May 21, 2013

The Foothills Development by Pino Dam, ZAP E-22

Lynn M. Mazur, P.E., C.F.M.

Development Review Engineer

TITLE:
**THE FOOTHILLS
PINO ARROYO STA 10+00 - END**
CONCEPTUAL PLAN AND PROFILE

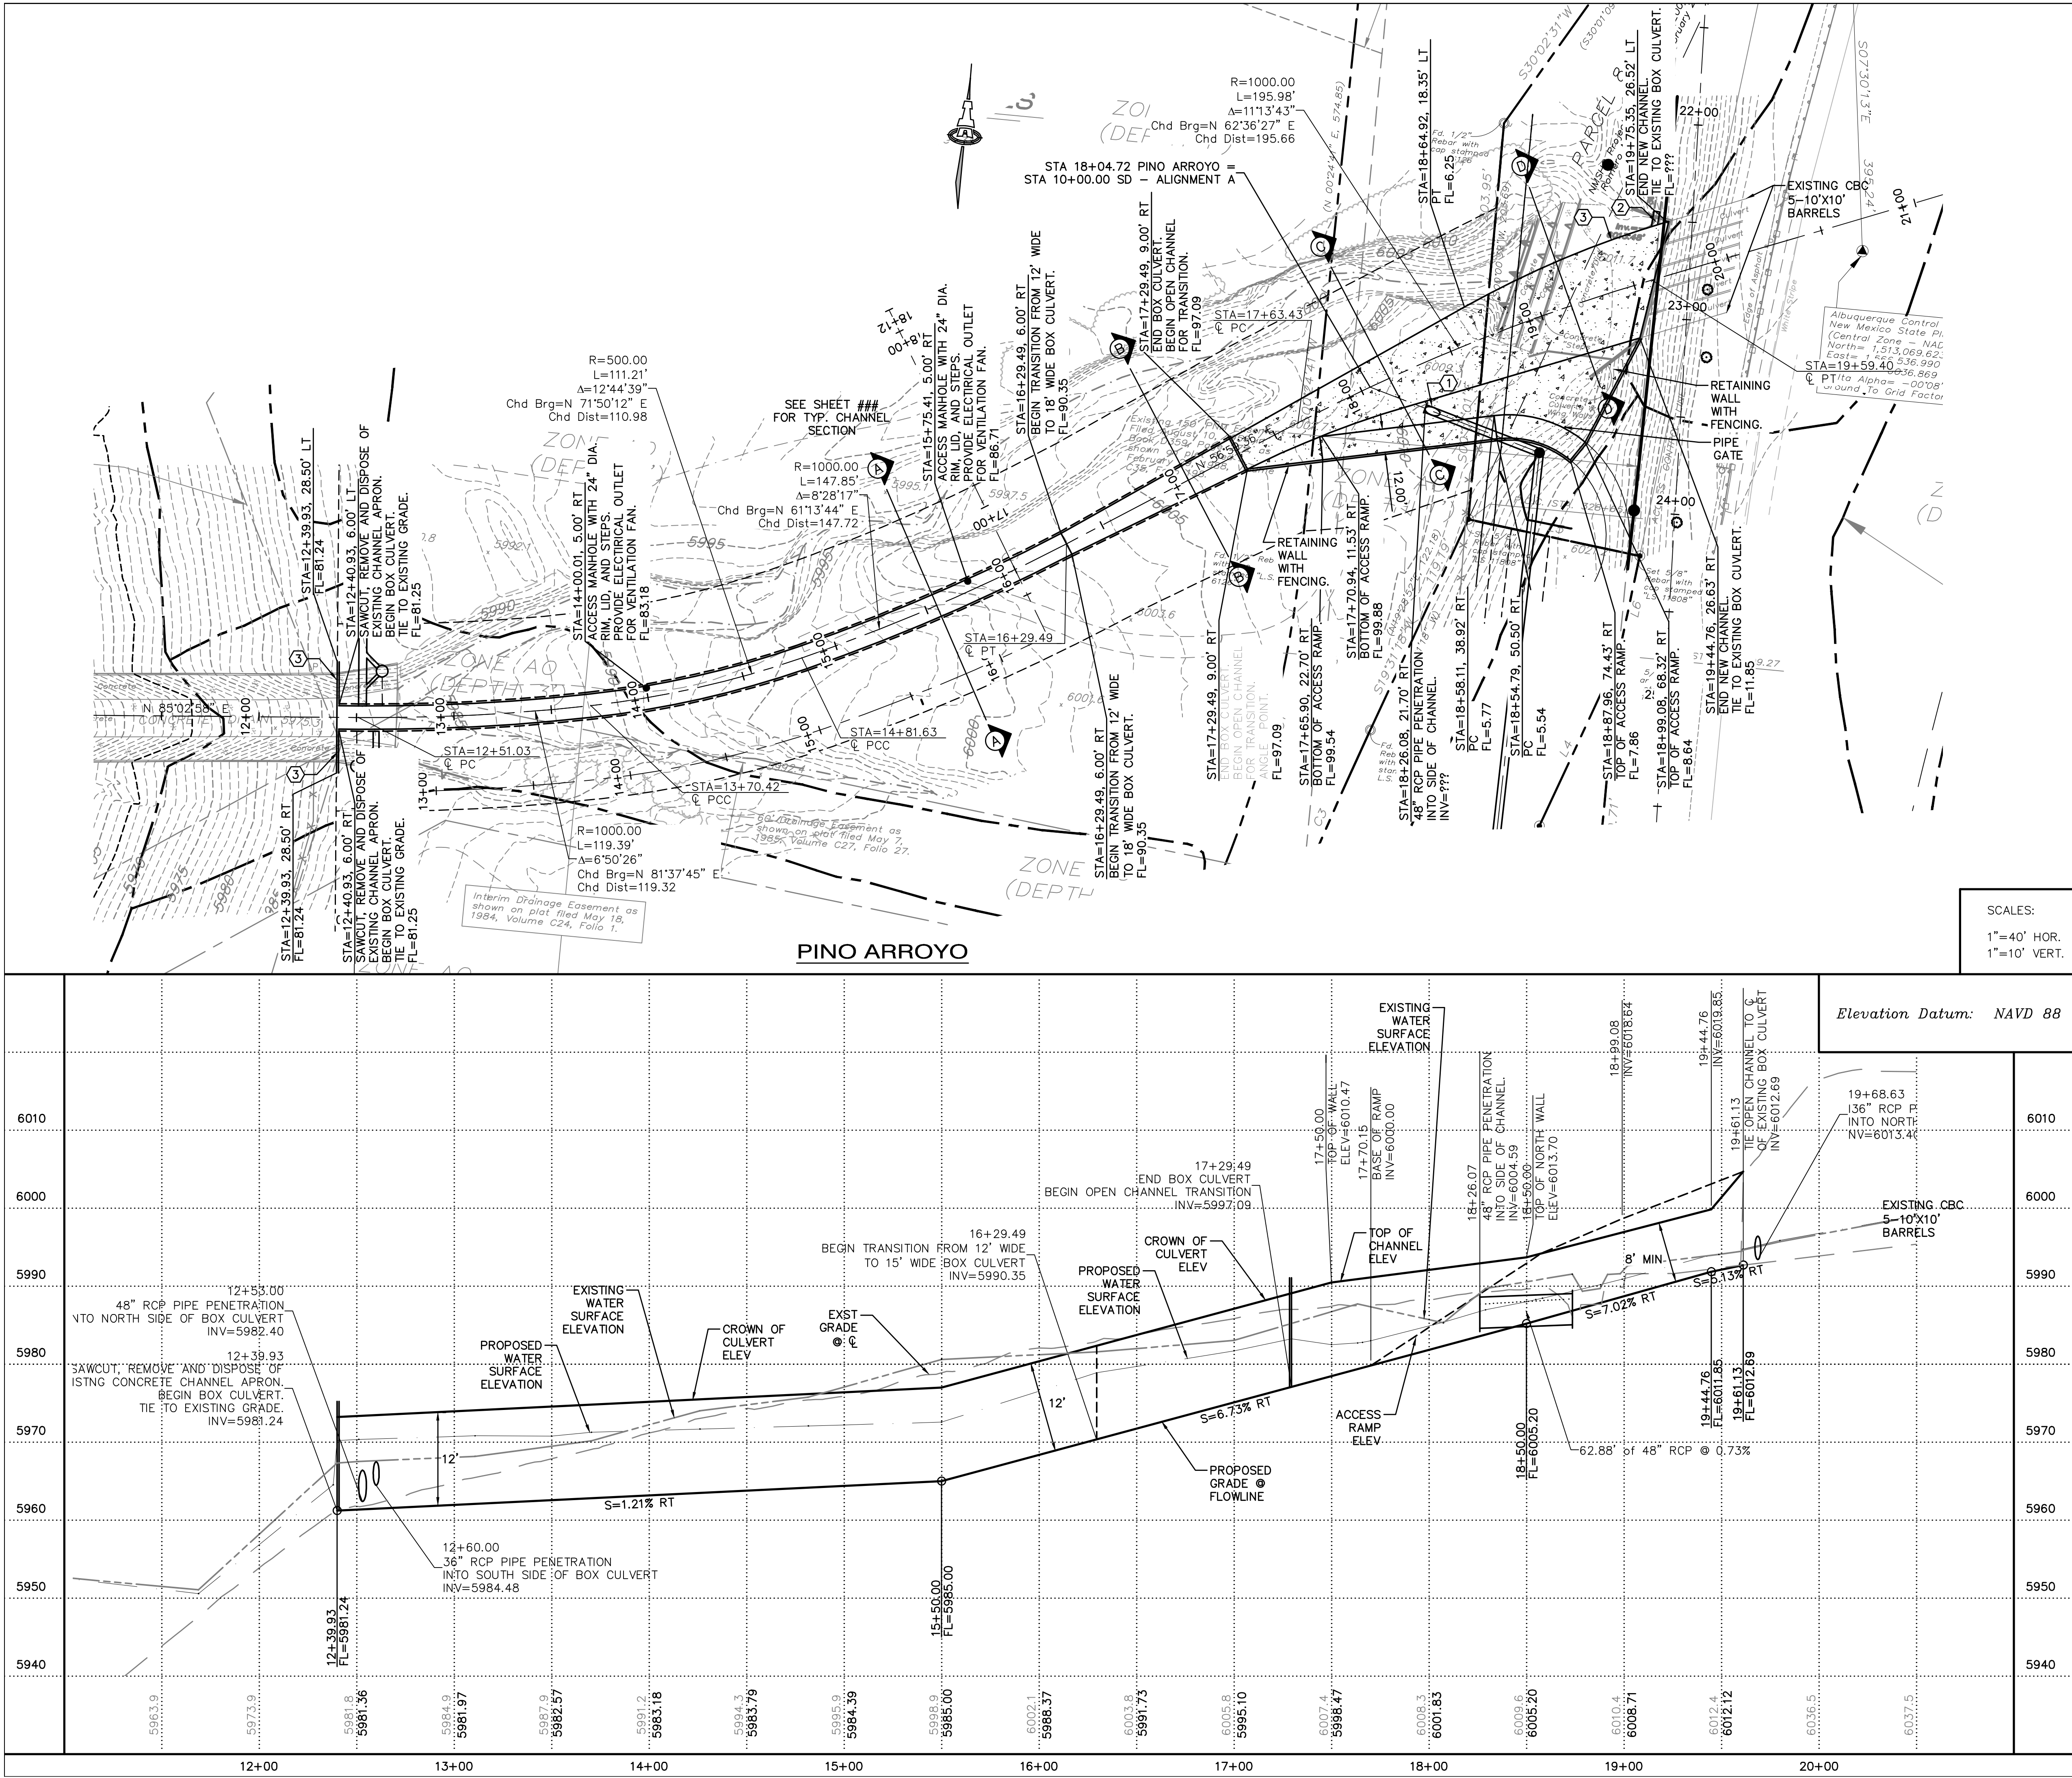
The grading for the improved channel will still need to tie between the two properties and the box culverts at Tramway Boulevard. You will also need to show that the existing concrete rundown into the Pino Dam pool will provide adequate erosion protection.
